EPC STORMWATER REVIEW COMMENTS ARE SHOWN IN ORANGE BOXES WITH BLACK TEXT

2022 Financial Assurance Estimate Form (with pre-plat construction) mulching should match seeding quantity

PROJECT INFORMATION		
D49 Transportation Center	6/15/2022	
Project Name	Date	PCD File No.

\\s4565\Drawings\4565-RE-ESP-02.dwg, 9/20/2022 - 5:20 PM, AMB

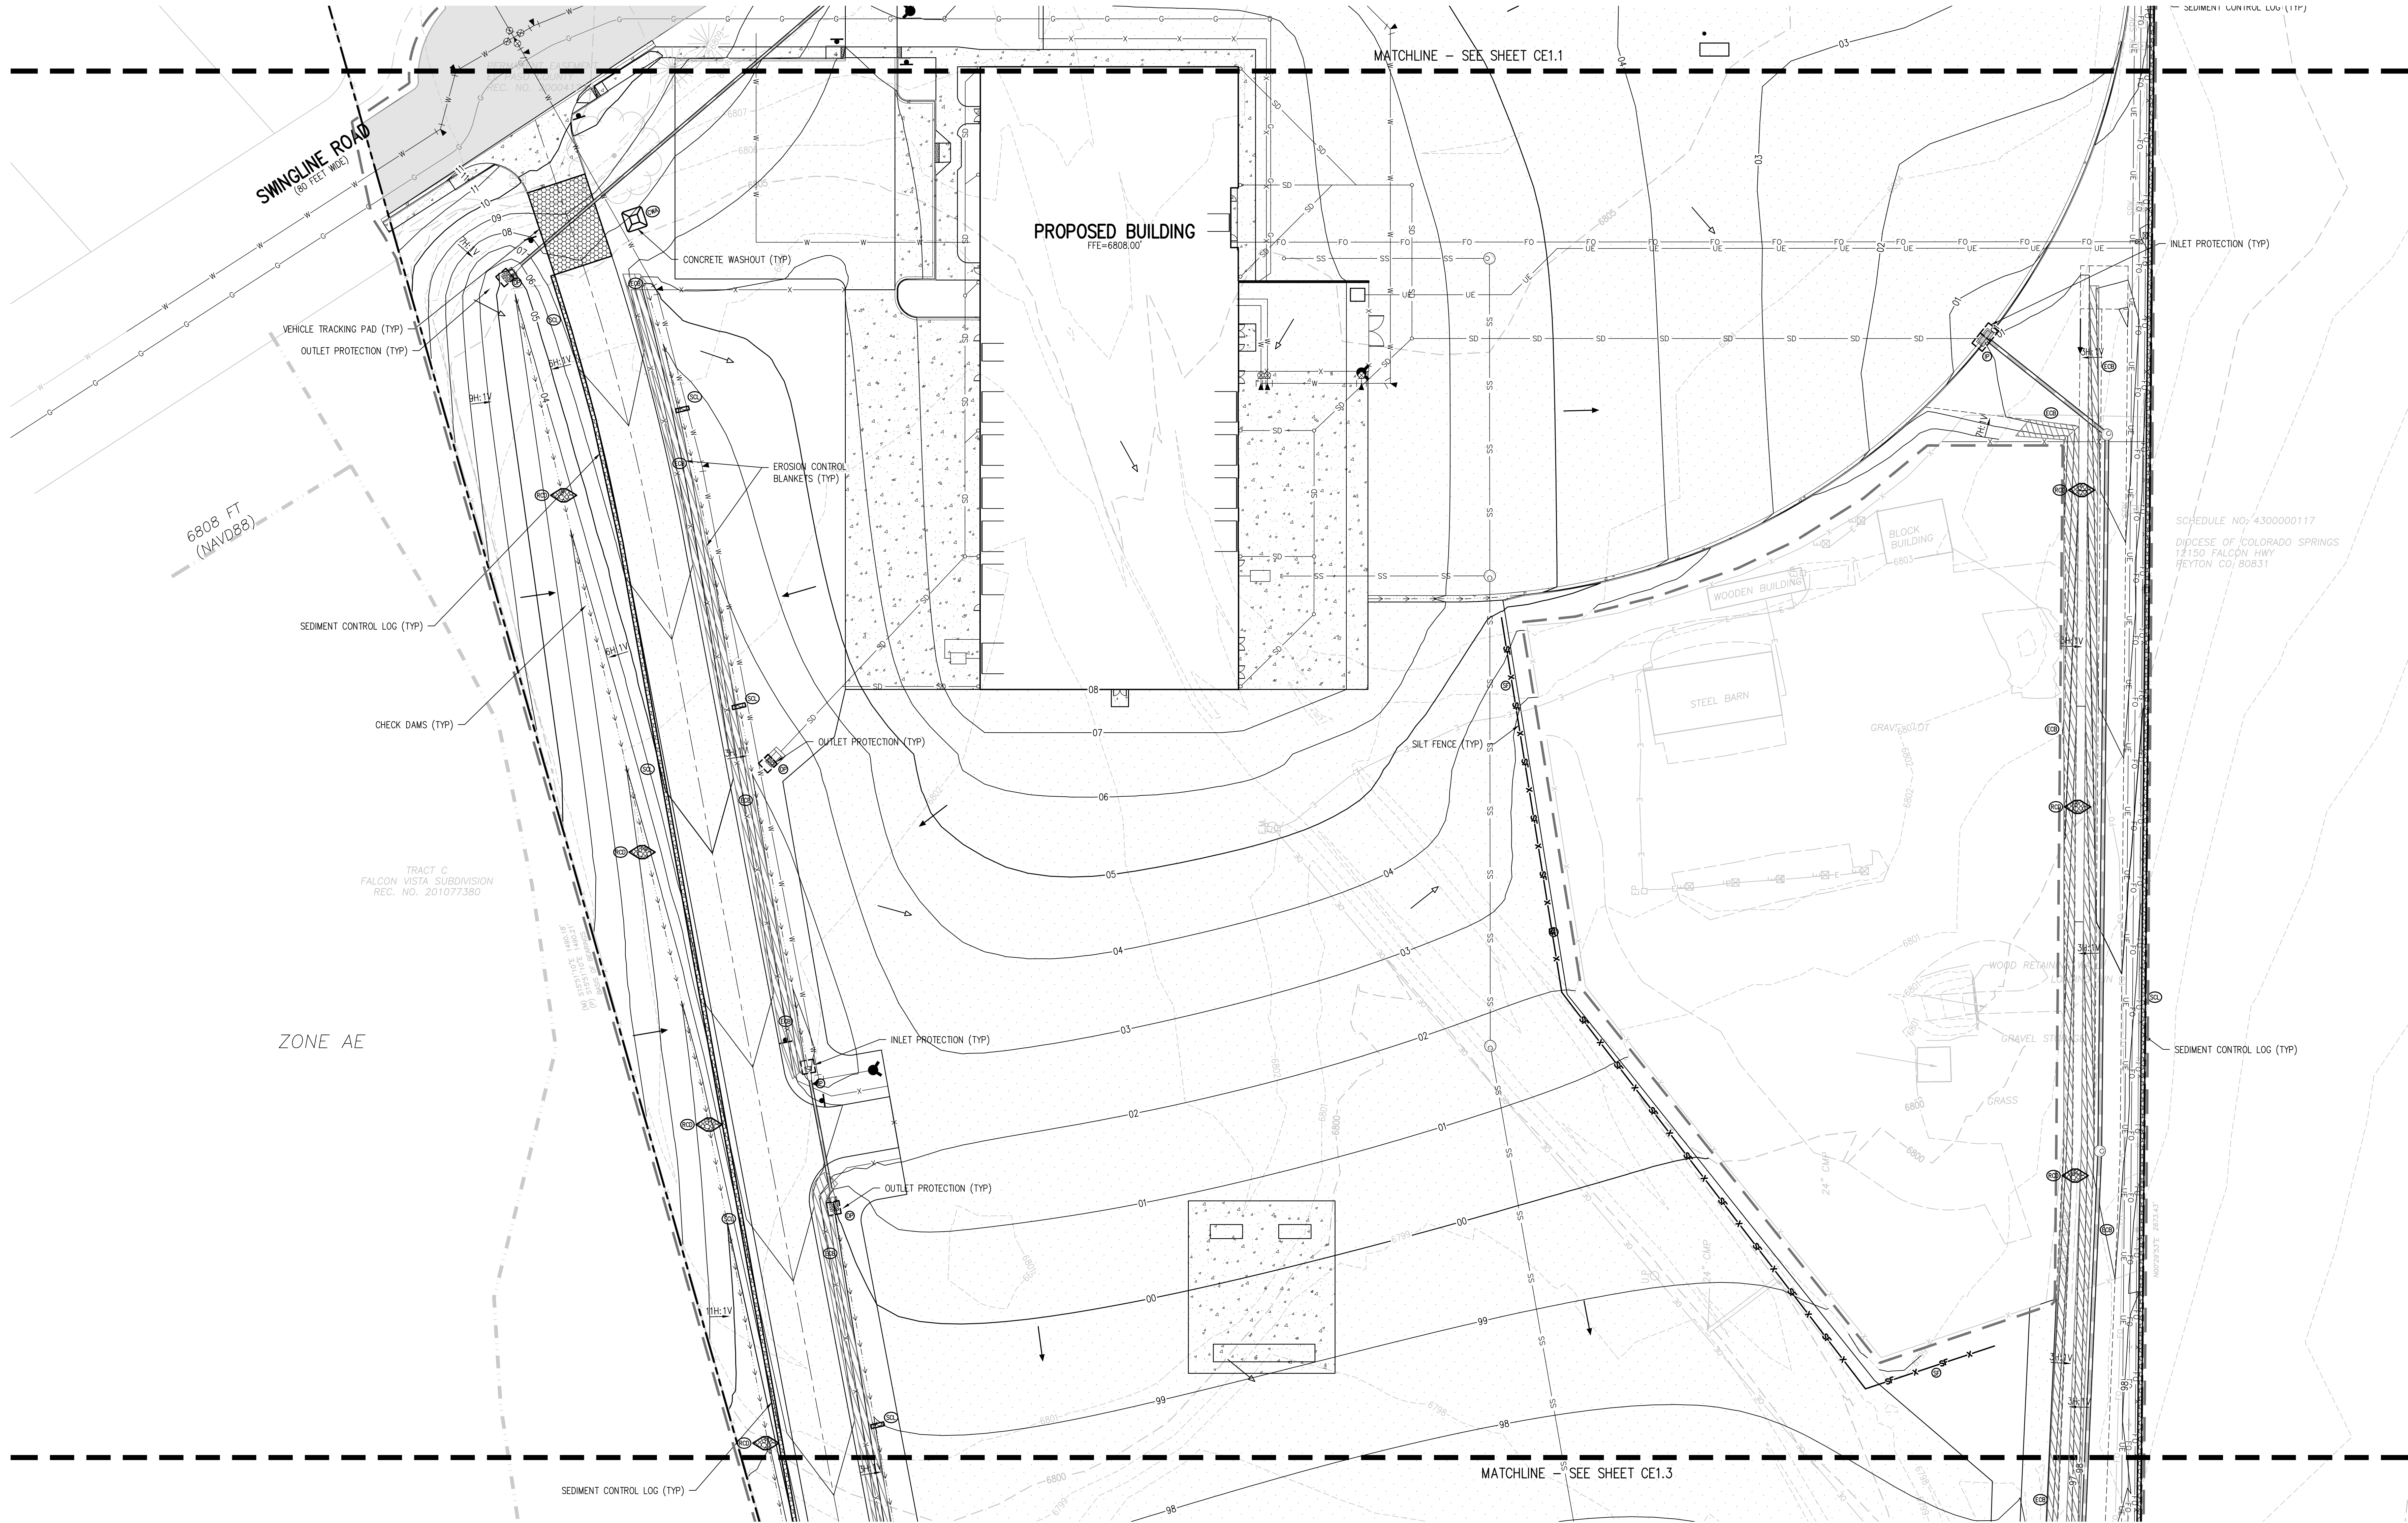
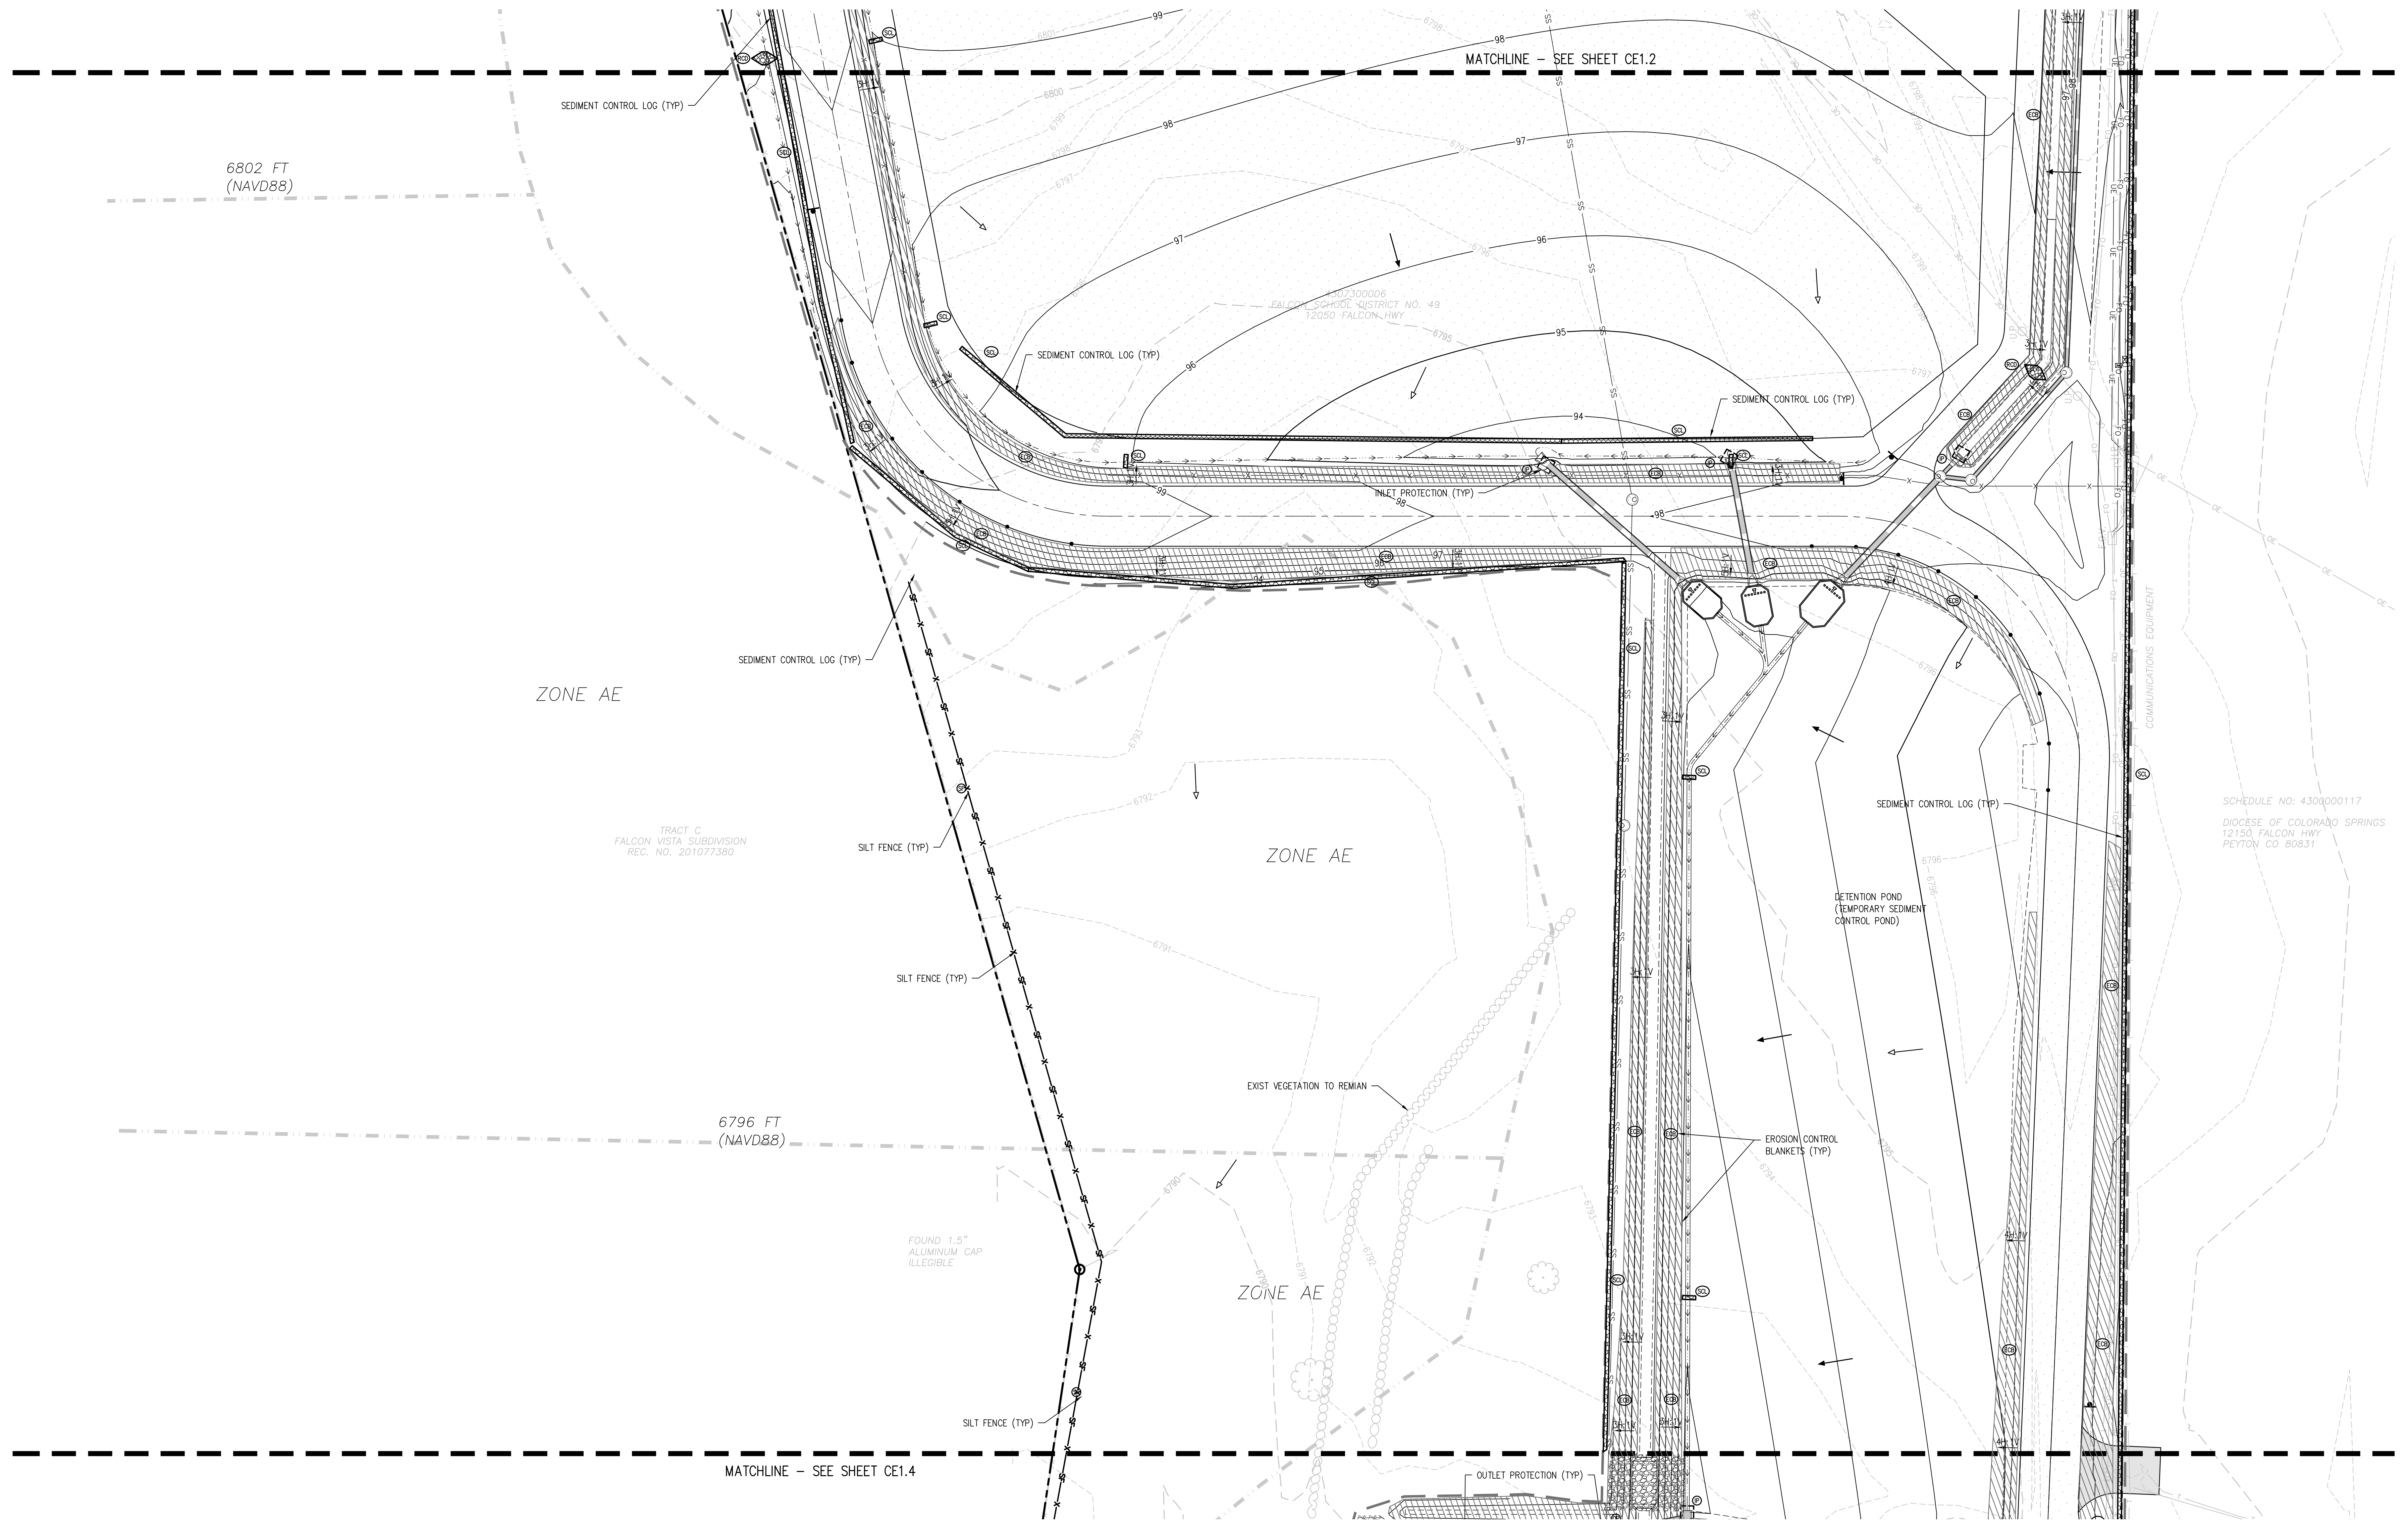
RCDs shown on figures
